## CBD & South Eastern Light Rail Project

### Royal Randwick Racecourse submission to Preferred Infrastructure Report

Submitted to Planning and Infrastructure NSW

April 2014

Figure 7-18: Royal Randwick Racecourse Precinct Access Plan

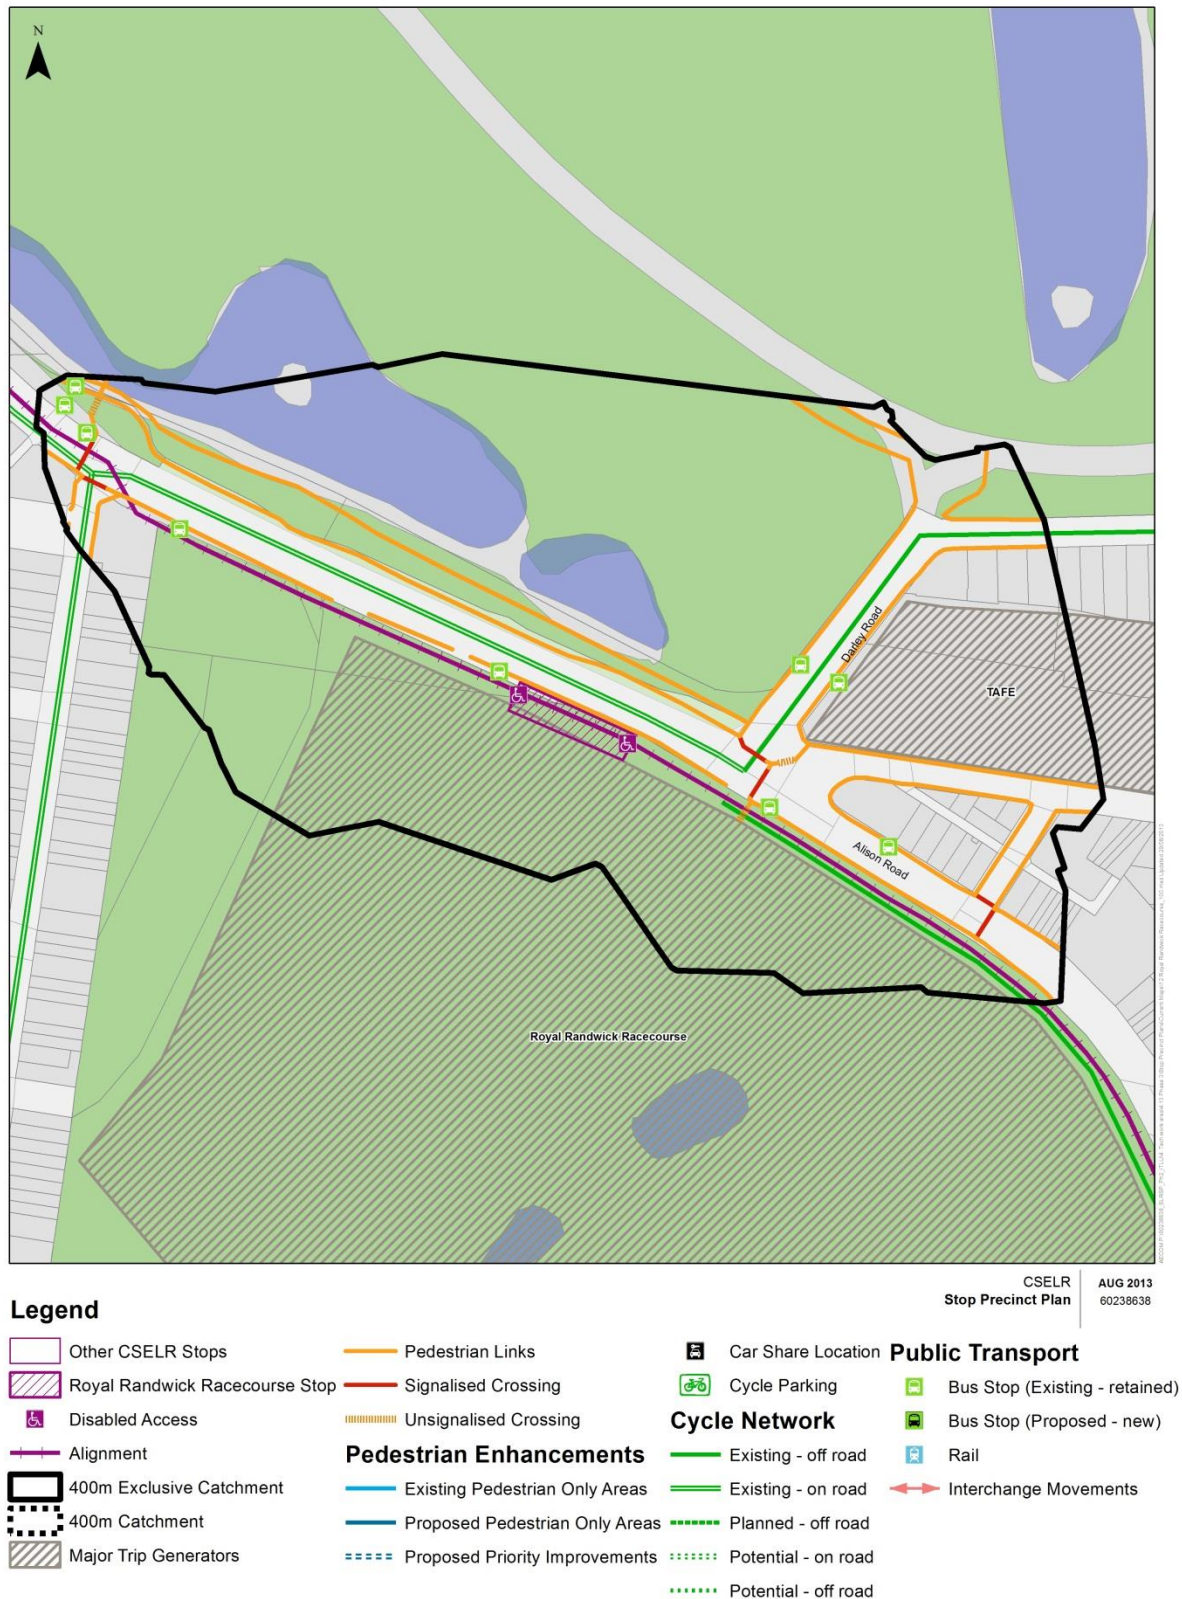
The EIS did not provide sufficient eastbound access to the RRR for event buses and coaches for both raceday and non-raceday events.

The PIR proposes an amended design solution that enables buses to enter into a loop road from Alison Road eastbound along King Street, John Street and westbound down Alison Road, then crossing the proposed Light Rail line to access the RRR. This design solution removes the existing situation where buses use the Darley Road roundabout to perform a U-turn manoeuvre to Alison Road to access the RRR site.

The PIR does not provide sufficient detail on proposed bus layovers or areas for set down/pick up and how these areas relate to the light rail operations, pedestrian movements and access into the RRR. An extract of the PIR detailing the proposed design changes is provided at Figure 2 below.

- *Exhibited proposal* - TfNSW acknowledge this proposal was unsafe for pedestrians
- *Busway* – the proposal does not provide sufficient detail for an appropriate area for set down / pick up of patrons to the RRR. Any bus area will need to ensure pedestrian safety at all times as well as resolve potential bus conflict with:

- light rail operations
  - existing traffic along Alison Road
  - traffic entering and leaving the RRR.
  - Pedestrians
  - The event stop
- *Impact on Spectator Precinct* - The buses appear to enter the Spectator Precinct which is likely to result in conflict with the high level of pedestrian movements during both raceday and non-raceday events in this area (this was also the case with the exhibited design).

- *Crossing light rail* – there is insufficient detail provided to demonstrate that buses can cross the light rail in a safe and coordinated manner. This has the potential to create confusion and potential conflict to both light rail and bus operations.

- *Pedestrian safety* – Does not appear to provide appropriate or best practice crowd management or acknowledge maximum crowd numbers and acceptable operations for bus numbers or mode min. In addition, it does not identify mode mix during peak operations or operational management plan.

The revised local access arrangement has merit by providing an alternate access arrangement for eastbound buses to access the RRR. Following consultation with TfNSW, the ATC proposes an alternative solution to address the loss of the existing busway (resulting from the RRR event stop) in conjunction with the proposed local access arrangements for buses as detailed in the PIR. Further details are provided in Appendix 3 and a recommended Condition of approval (A.32)

- Utilises existing signalised intersection at Darley Road and Alison Roads for buses to turn into the RRR
- Enables buses to cross the light rail at a controlled intersection
- Provides a well resolved bus set down/pick up area that addresses pedestrian, traffic, bus and light rail conflicts
- Designed in conjunction with an alternate light rail access to the LRV Stabling Facility and revised Gate 1 entrance to the RRR

Figure 7-19: Wansey Road Precinct Access Plan

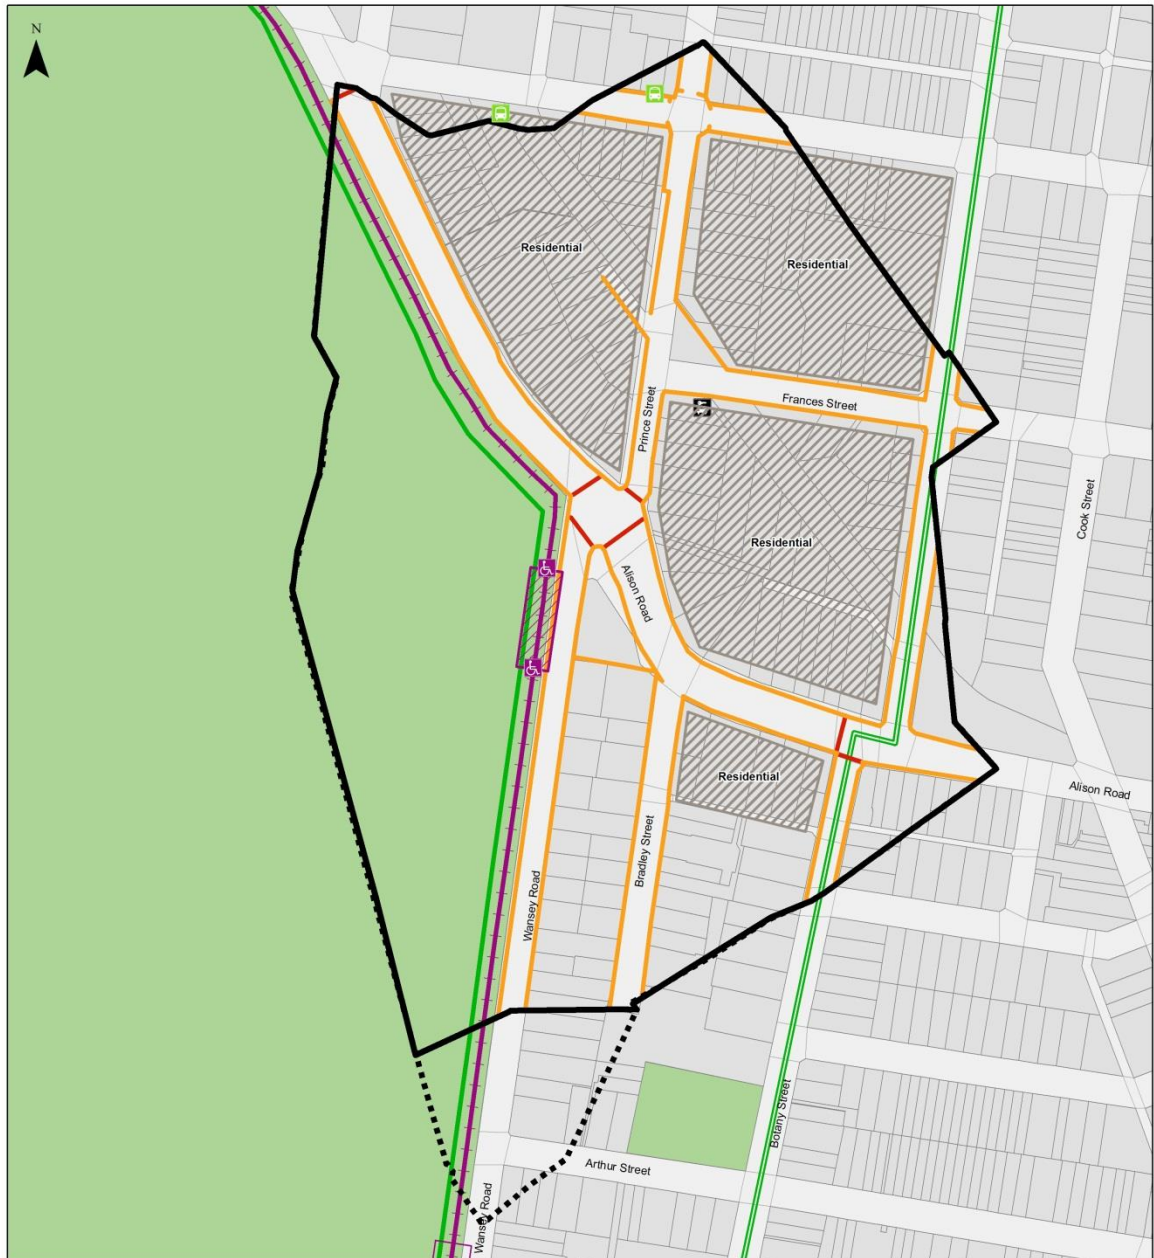
The EIS proposed a side running light rail alignment along the southern side of Alison Road and the western side of Wansey Road, which continued as a centre running alignment into High Street. The proposal resulted in the loss of all on-street parking along Wansey Road, with 2 light rail stops along the southern and northern ends of Wansey Road.

- Amendment to the alignment of the light rail along Alison Road
- Amendments to the traffic configuration of Wansey Road
- Re-location of both Wansey Road Light Rail Stops into Alison Road and High Street respectively.

- Gate 8 access be replaced by a new Gate 7A allowing heavy vehicle access from Cowper Street
- The ATC is provided with appropriate compensation for the loss of any structures on the RRR site including the existing residence located near the corner of Alison Road Wansey Roads. This is to include beautification of the area, including major planting to ensure a high quality appearance from the spectator precinct.
- Appropriate treatment of any retaining walls along the RRR boundary

- All RRR boundaries/frontages must address visual impacts and ensure appropriate landscaping, fencing, lighting in future consultation with the ATC and Randwick City Council
- The proponent must address any impact on the approved equine stables design prior to construction.
